CM 16/20/PL and CM/64/19/PL Langford, Horsemere Green Lane, Clymping

Plot 8 deliberate misrepresentation by applicant MJH Homes to ADC

Drawing Title:
HOUSE TYPE-F1
FLOOR PLANS

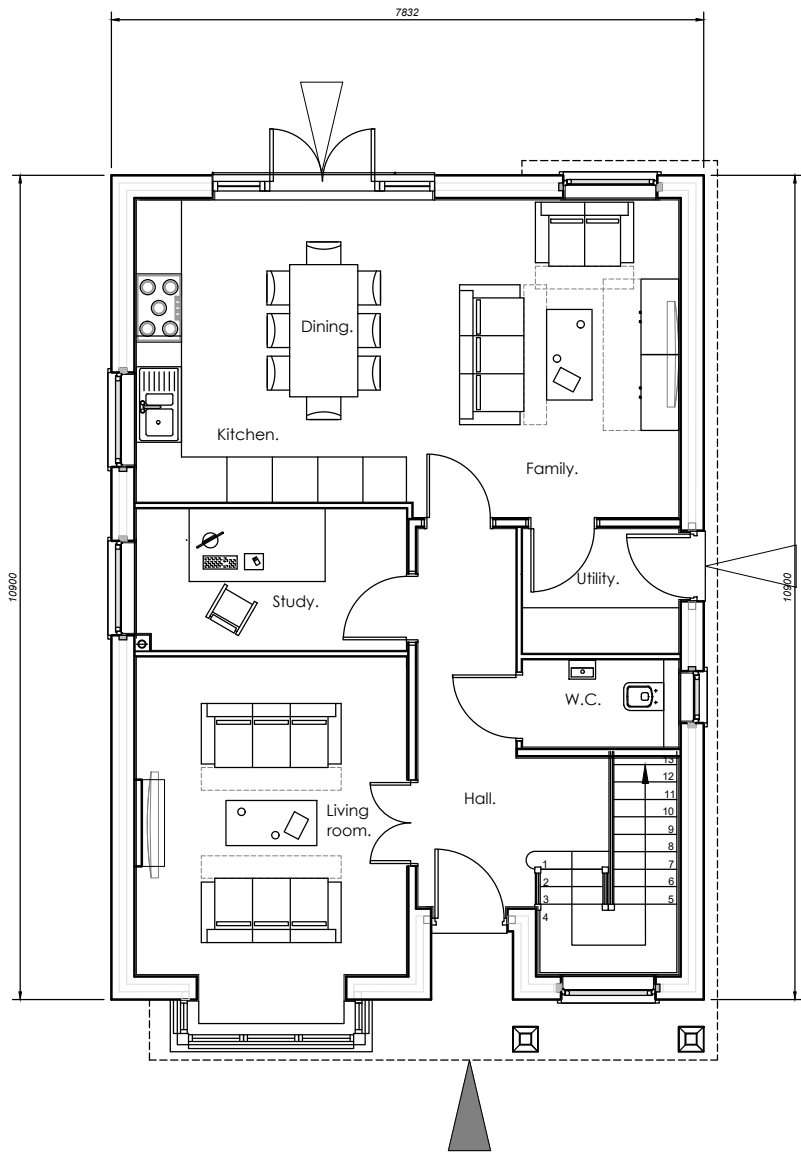
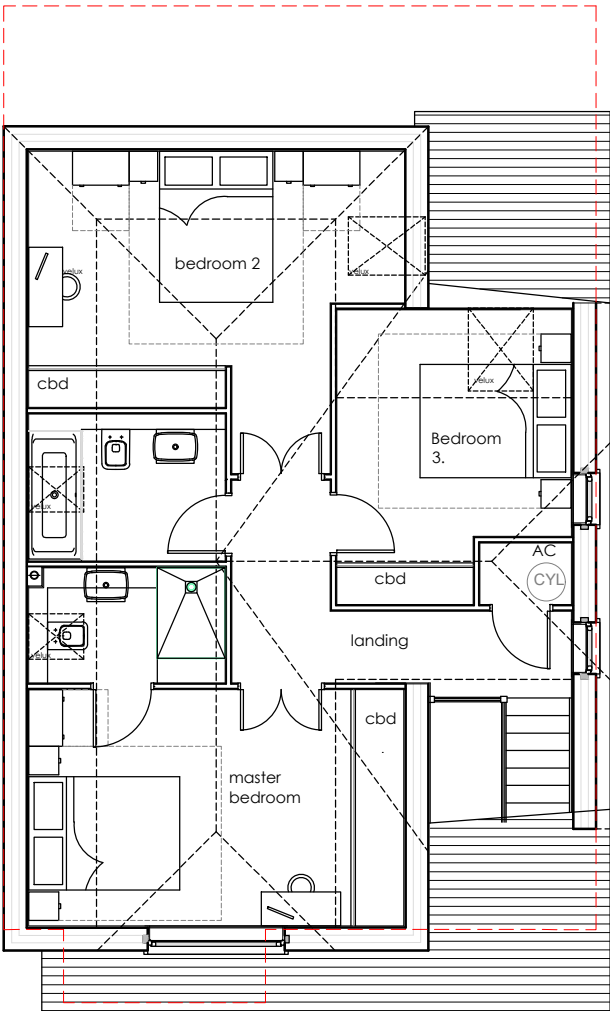
3. The value of my property has been very badly affected.
4. PLOT 8 runs the length of my boundary. An application for a 4-bed house type E was submitted and declined. House type F described as a 3-bed BUNGALOW but which in fact was a HOUSE with 2 bedrooms and 2 bathrooms on the first floor, and one bedroom on ground floor was submitted.

6. A proposal now for an even larger house, in every sense, F1.
7. Whereas before my outlook was that of natural woodland, the applicant proposes impose that I should have a view of this high expanse of brick wall and roof tiles.

9. Windows on the first floor which open out directly onto my back garden and can see directly in my bedroom windows, back windows generally and the whole of my back garden is completely unacceptable and a total invasion of privacy

Drawing Title:
HOUSE TYPE-F1
ELEVATIONS

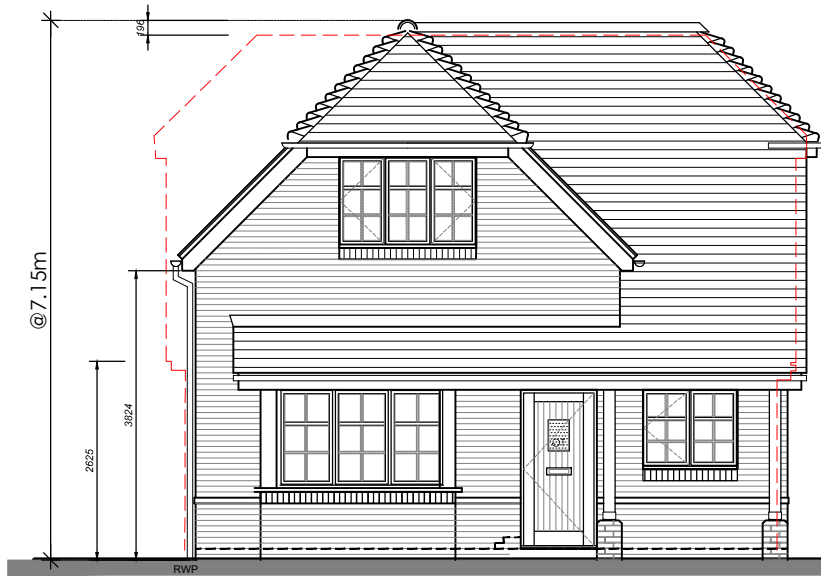
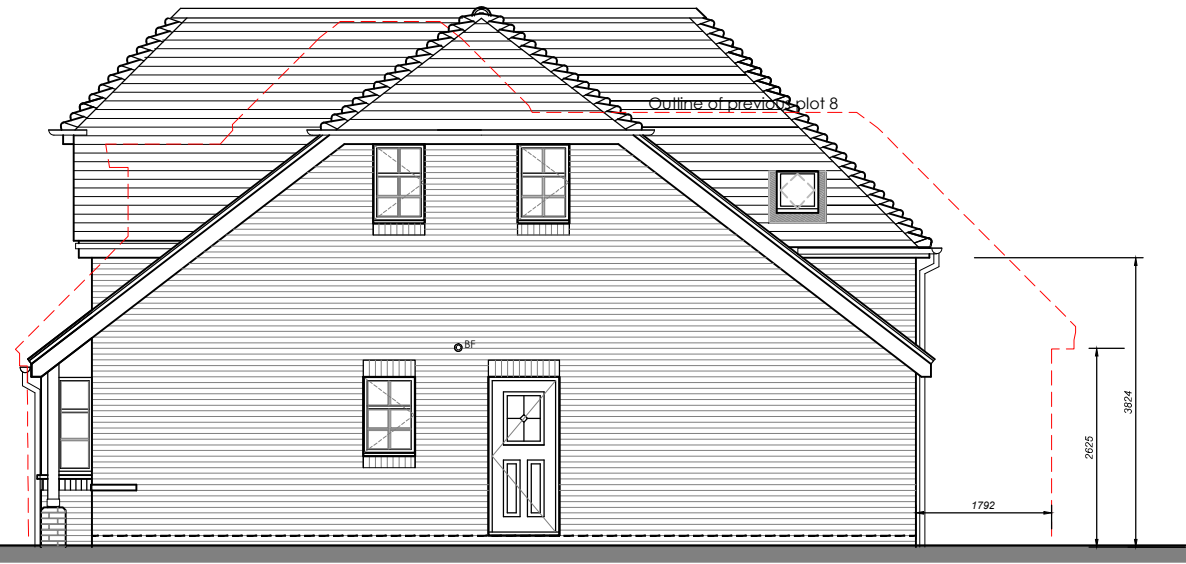
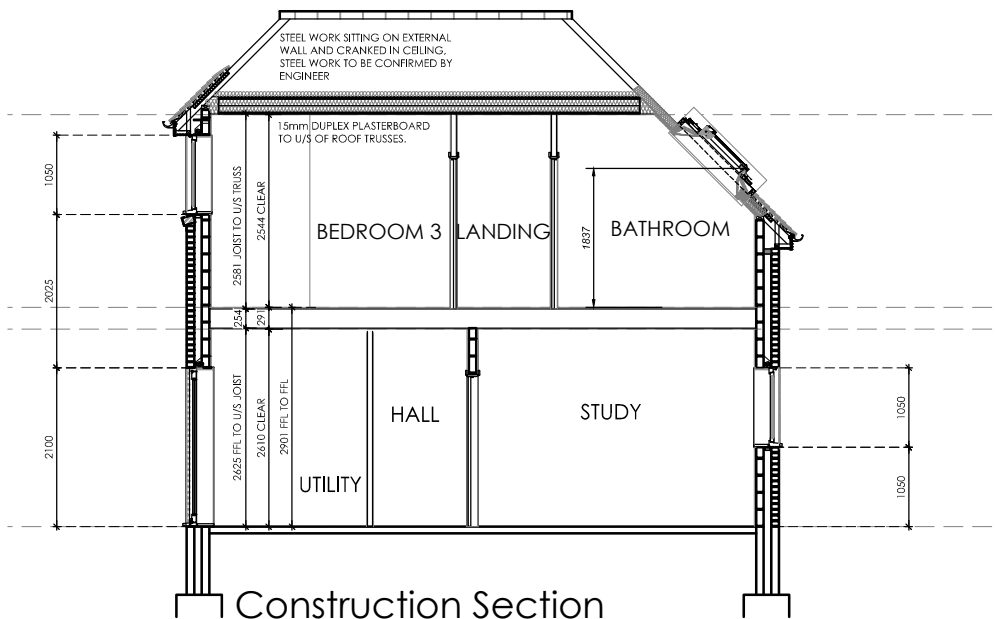
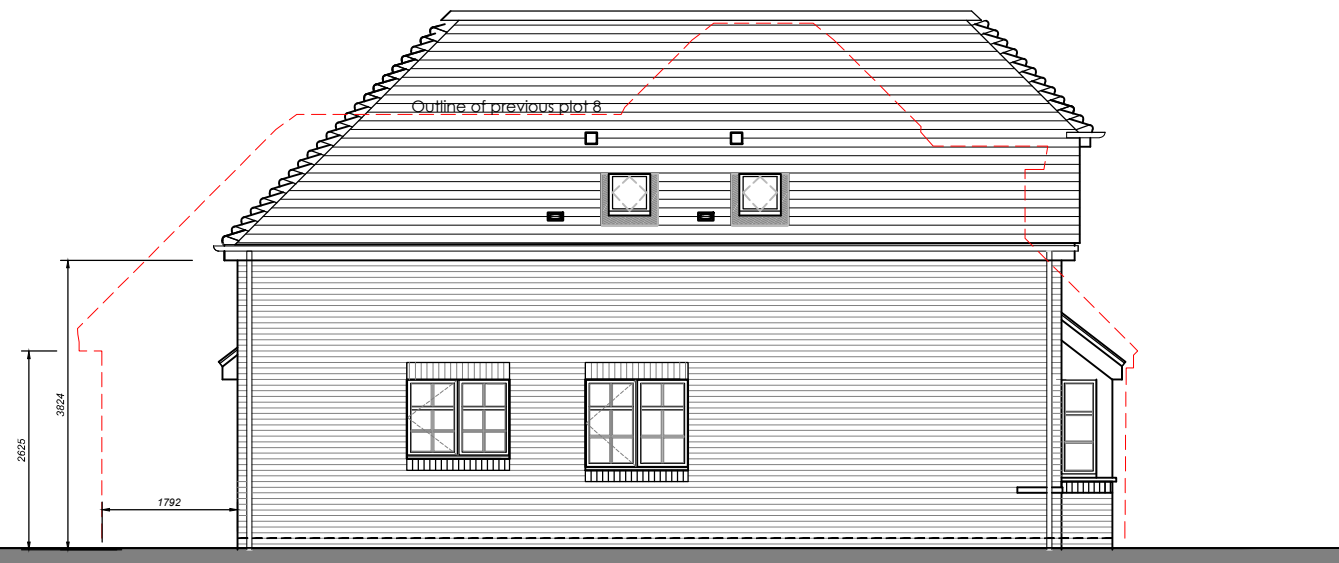
8. The whole length of the proposed house runs the whole length of my boundary, with permanent structure within feet of my fence/ property. This is very intrusive, and the high roof line will obliterate light for the majority of the day, completely unacceptable. I speak on behalf of myself and my affected neighbours.

13. If the applicant was to reduce the roof height to single storey, ie, that of a bungalow, as proposed, and lower the ground level, this would fall in line with their proposal of '2 x 3-bed bungalows' made to Arun District Council.
